Online Comment

Application H05-0739-22
Location Mill House Farm Roman Bank Fleet PE12 8LW
Proposal Details of external plant/equipment, foul & surface water disposal and ecological biodiversity measures. (Conditions 7, 11 & 12 of H05-0982-21)

Name Sue Armour
Address Team Leader Environmental Protection SHDC

Our officers have reviewed the Blue Tree Acoustics report 'Agricultural Produce Store, Mill House Farm, Roman Bank, Fleet Hargate Noise Assessment Report Doc ref: 03686-140101 21/07/2022'.

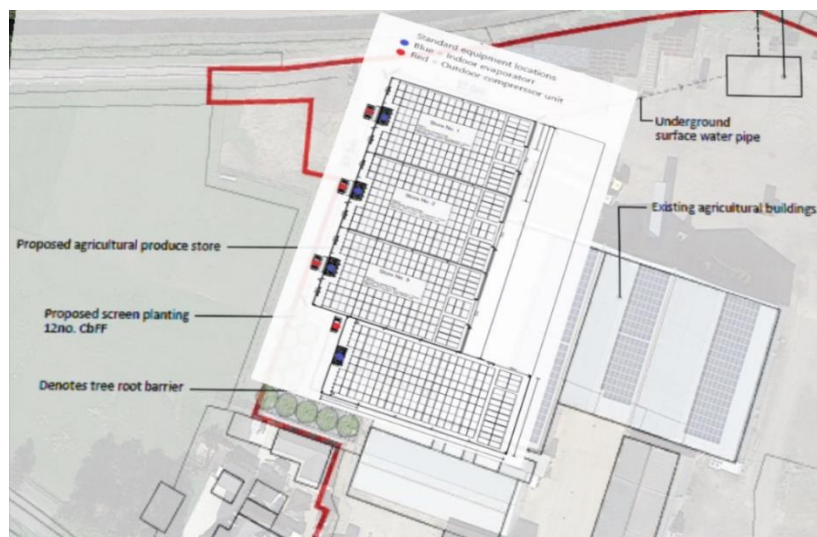
Using computer noise model predictions and manufacturers data for the fixed plant that is proposed to be installed on site, cumulative noise emissions from the proposed plant (including new plant covered by the planning permission and also the new plant serving the permitted development) are shown to exceed the planning condition noise criteria during both the daytime (by 10 dB(A)) and night-time periods (by 17dB(A)) at the closest receptor, and night-time periods at the second closest receptor (by 9 dB(A)). This is in excess of the requirement of condition 6, which states not more than 5 dB(A) above background.

Initial predictions based on the information made available indicate that in order to achieve the planning permission noise criteria on the worst affected residential boundary, noise mitigation measures may need to address noise breakout from the building envelope as well as noise emissions from the fixed external plant.

In order to minimise the impact of noise emissions from the proposed new units the applicant should explore further noise mitigation measures, beyond those already incorporated within the latest design layout and these additional measures should be designed to restrict specific noise emissions from the new plant to below LAeq,15mins 47 dB(A) during the daytime period and below LAeq,15mins 40 dB(A) during the night-time period, when assessed at any residential site boundary.

FIGURE 1 – SITE PLAN OVERLAY AND APPROXIMATE MEASUREMENT LOCATION

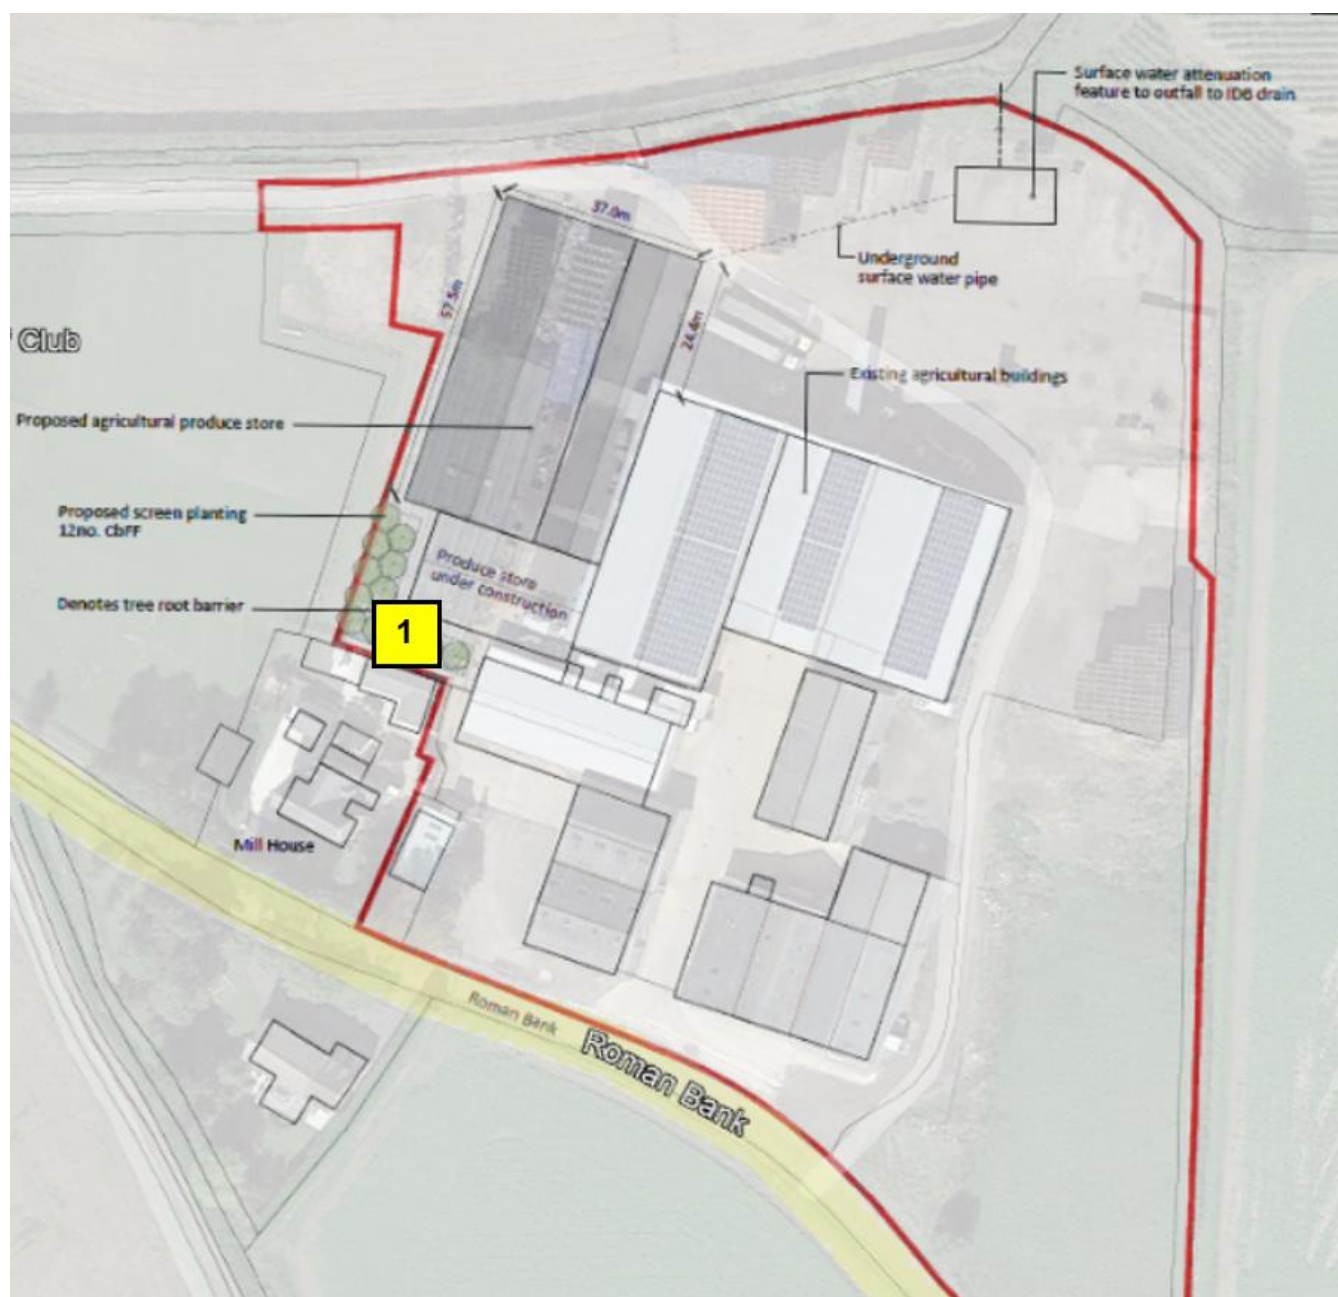
Our officer felt that the background noise levels recorded were considerably higher than those usually associated with such a setting in a rural area of South Holland. Whilst the report does note that there was some construction ongoing at the time of measurement, our officer still felt that the background levels presented were not necessarily representative of the usual conditions.
